Erection of a two storey rear extension, second storey enlargement of side dormer and conversion of garage to study including demolition of existing conservatory
100 Sea Road East Preston

Thank you for your internet representation made on 20th December 2018 which has been recorded as '**an objection**' with the comments as follows:

I am commenting on this application on behalf of the East Preston and Kingston Preservation Society.

PROPOSED FLOOR PLANS 1:50

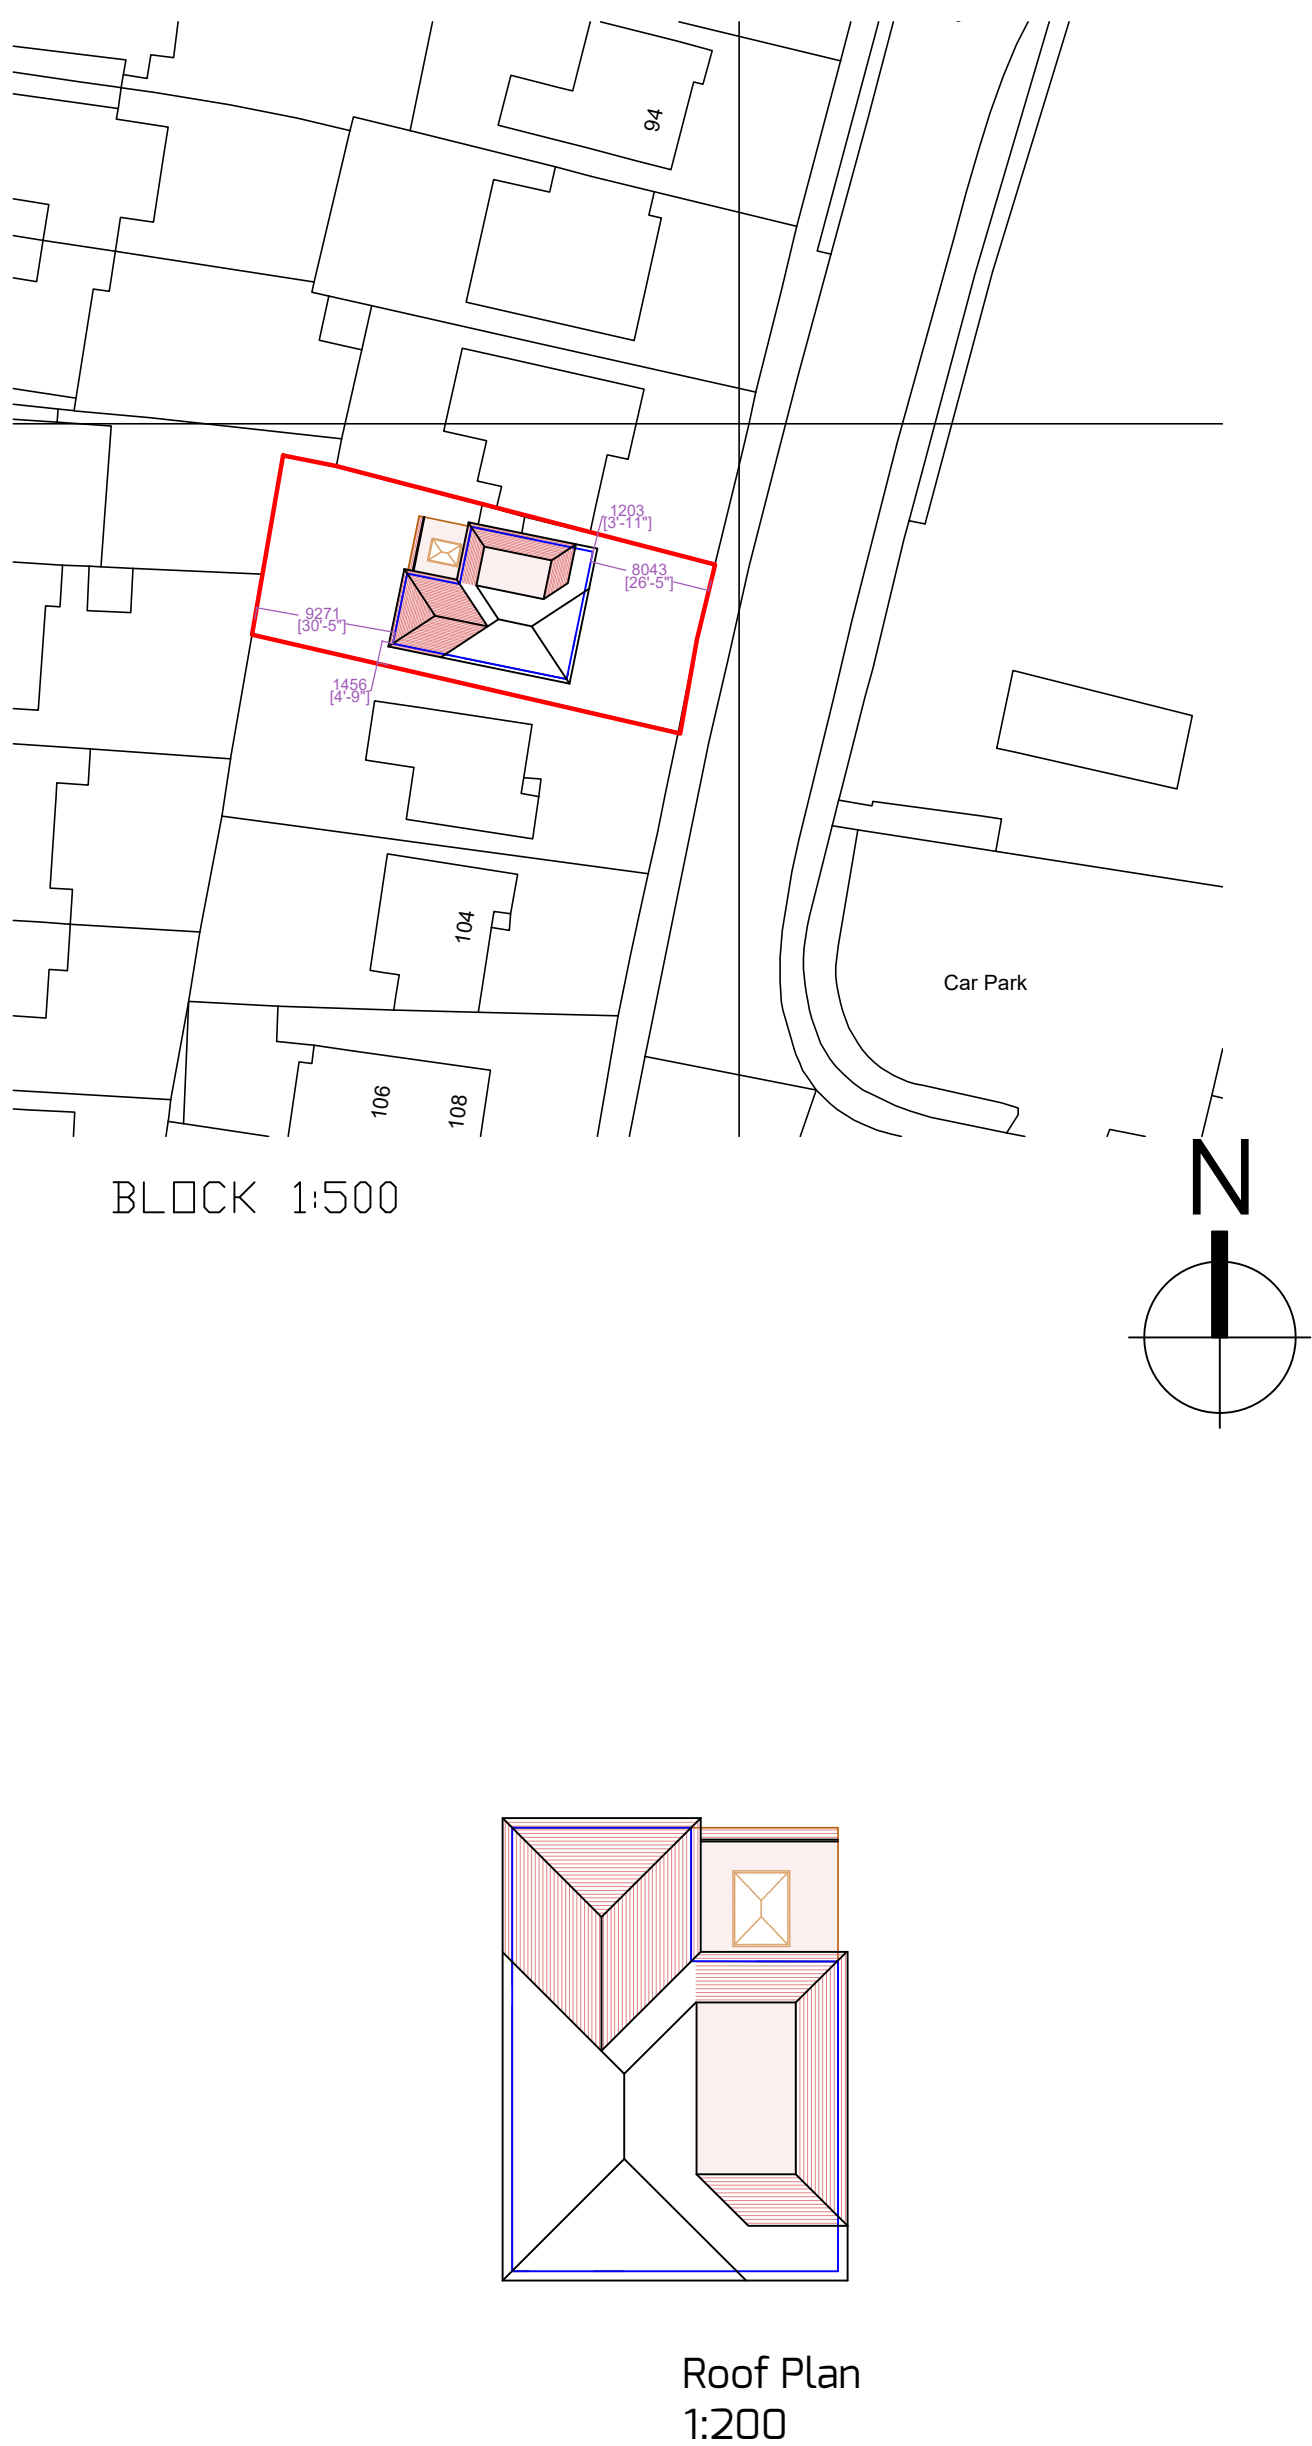
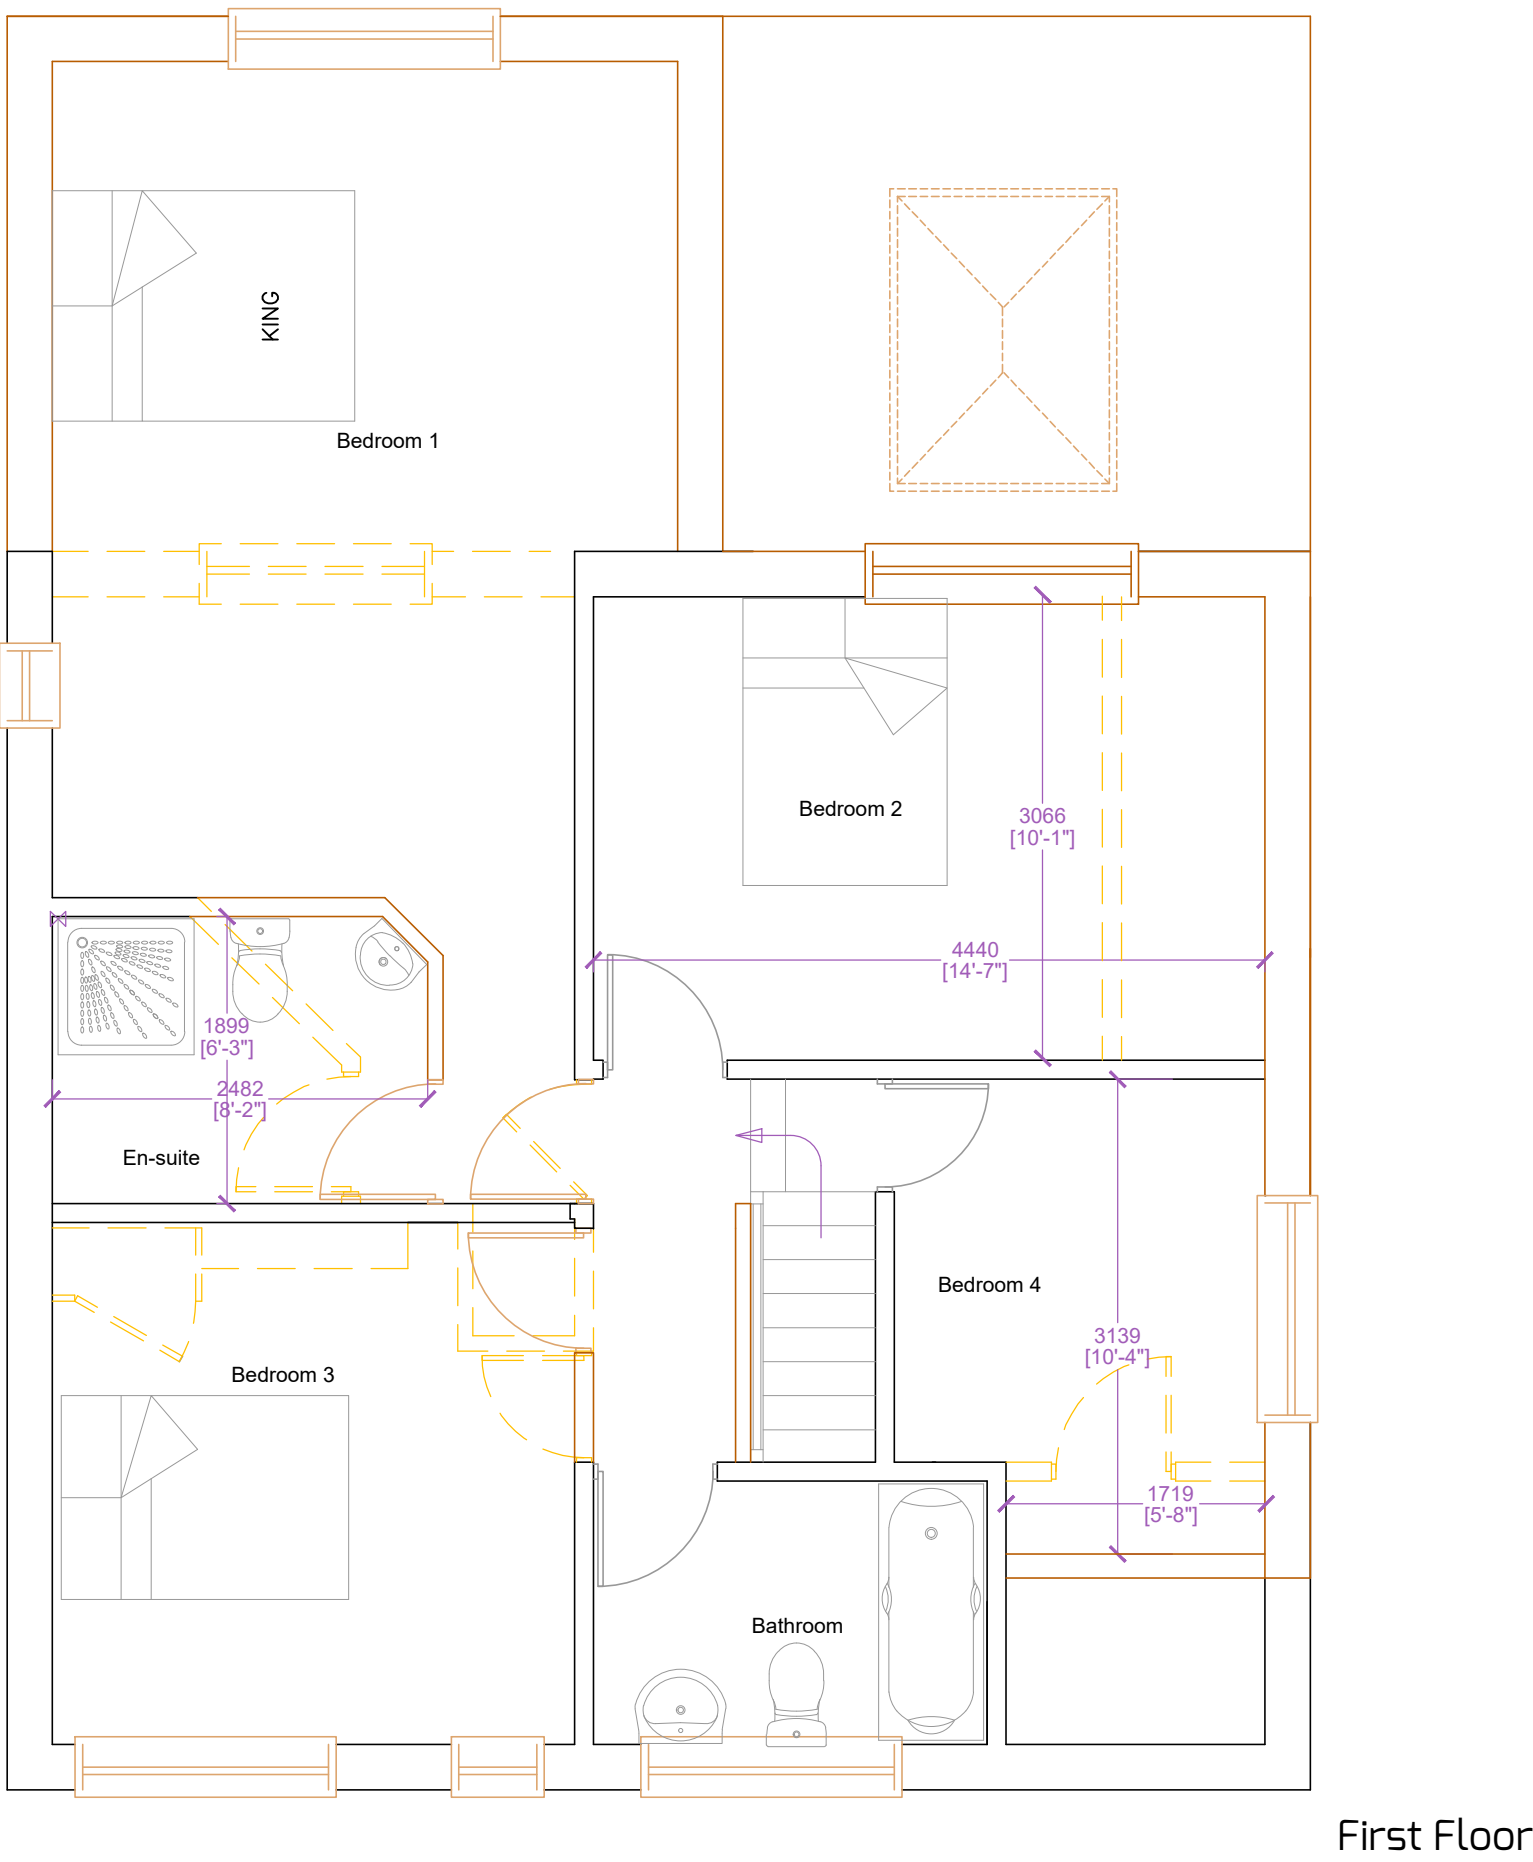
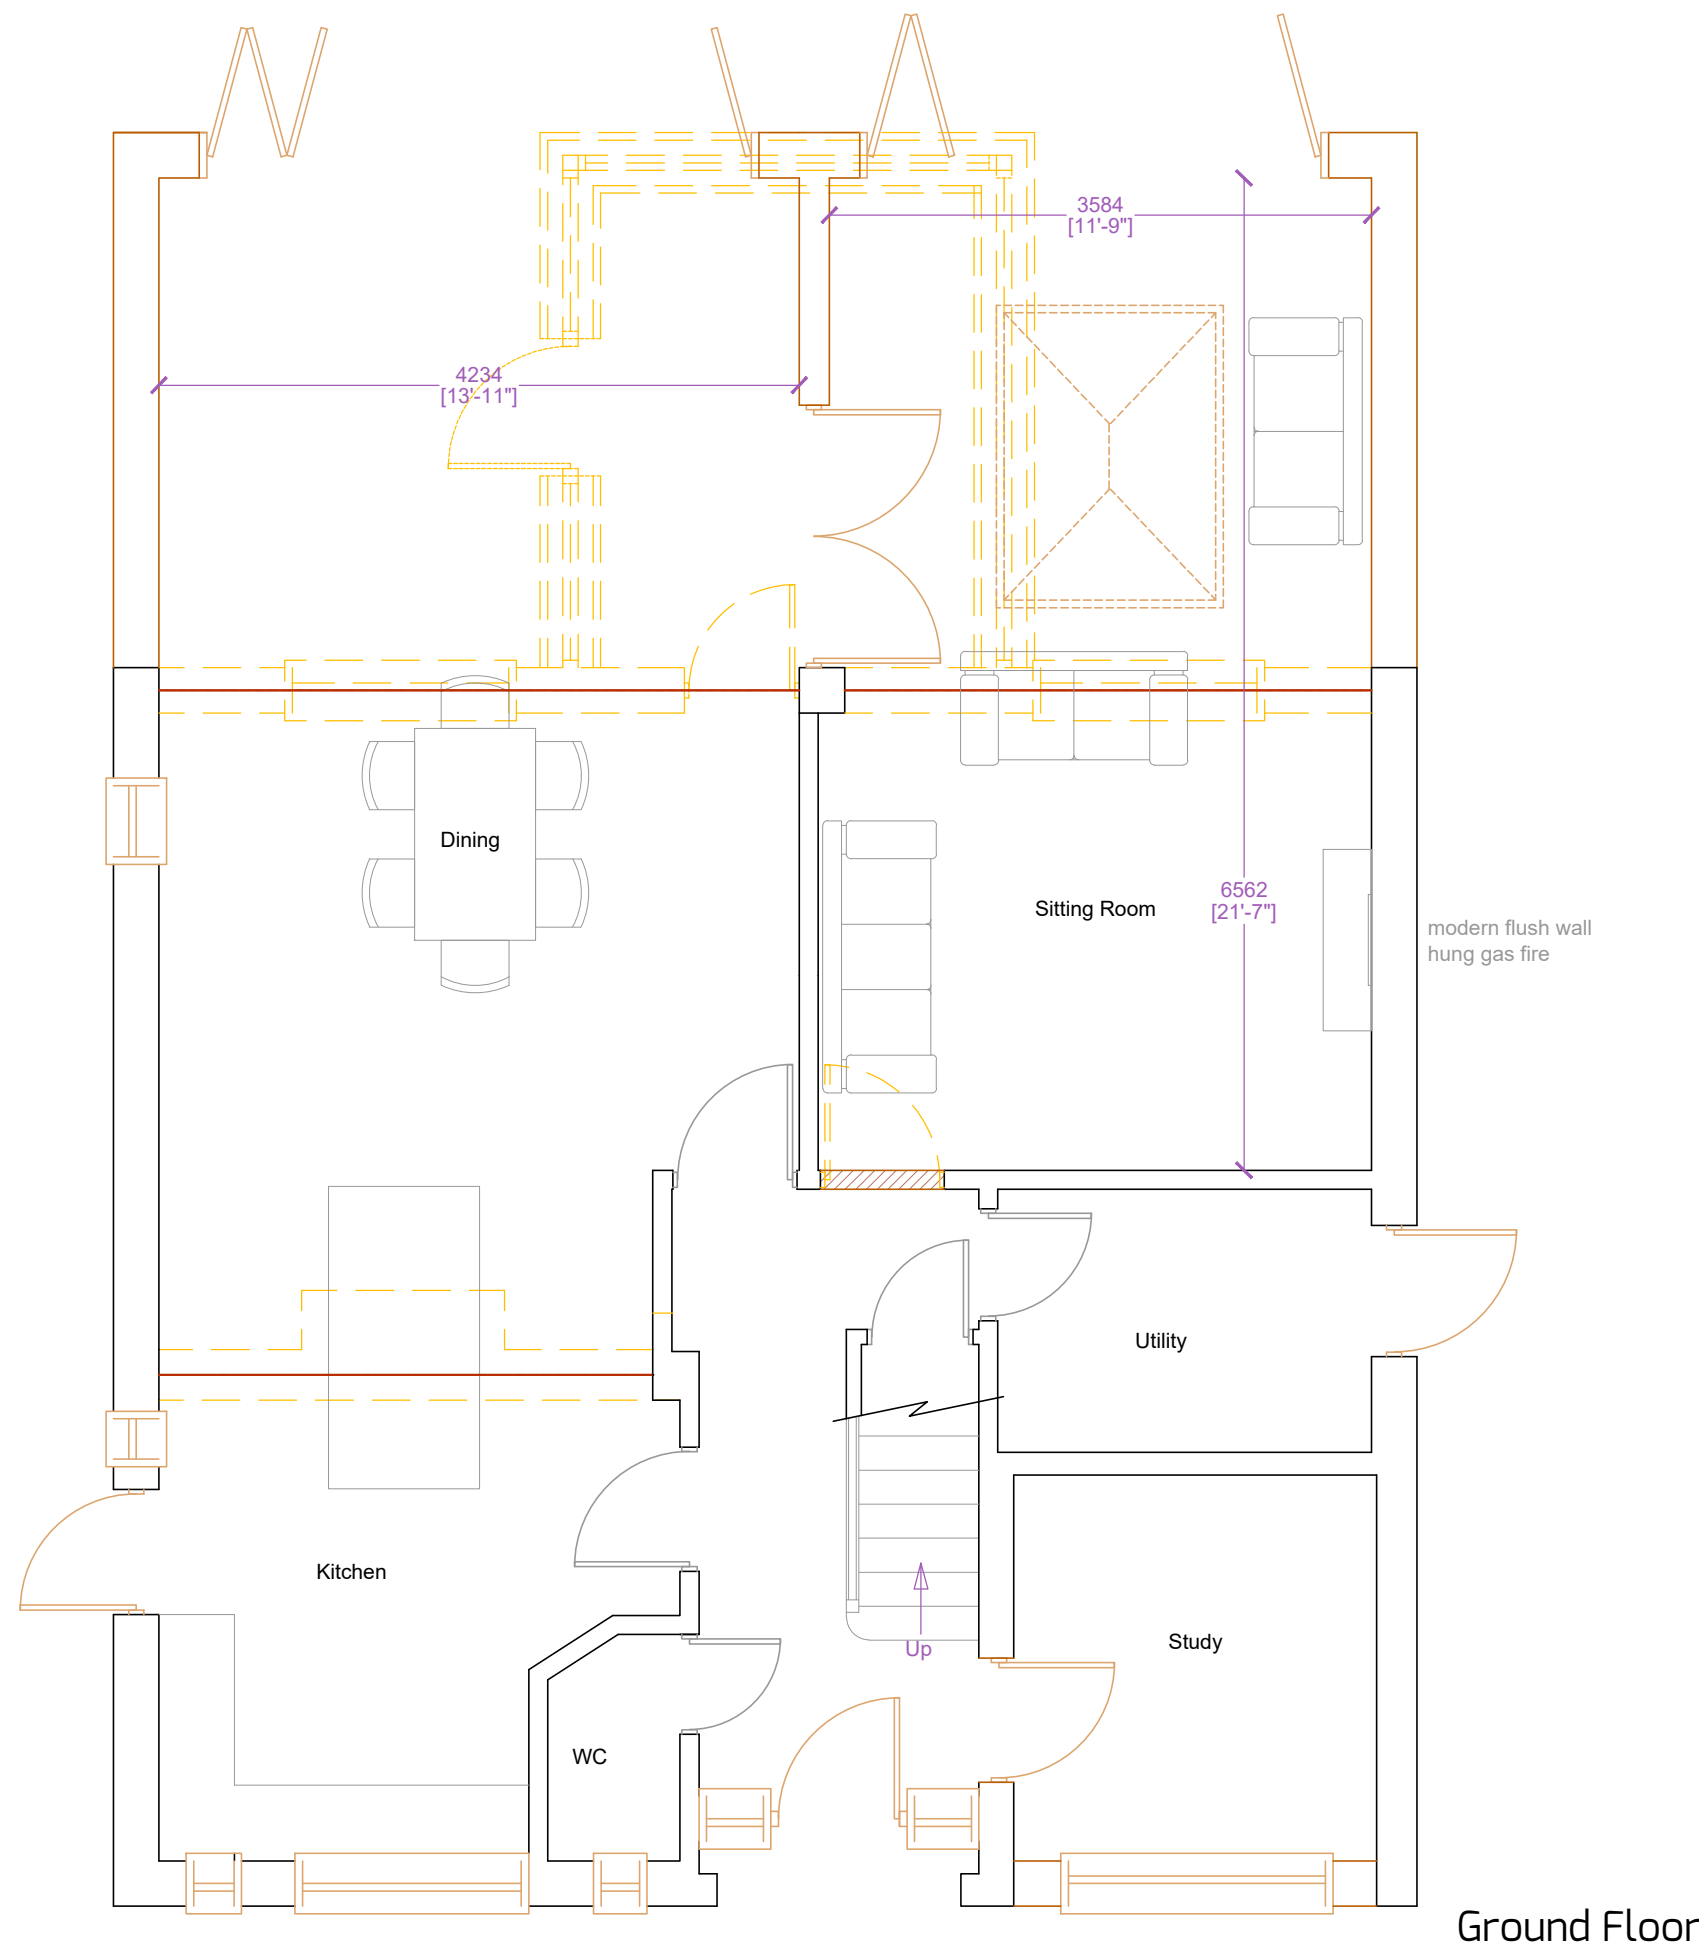
The two story rear extension would have significant impact on the adjoining house, 102, and on the bungalows close behind in Normandy Lane. This extension would therefore contravene policy D DM4 of the Arun Local Plan, because it would be overlooking and overbearing.
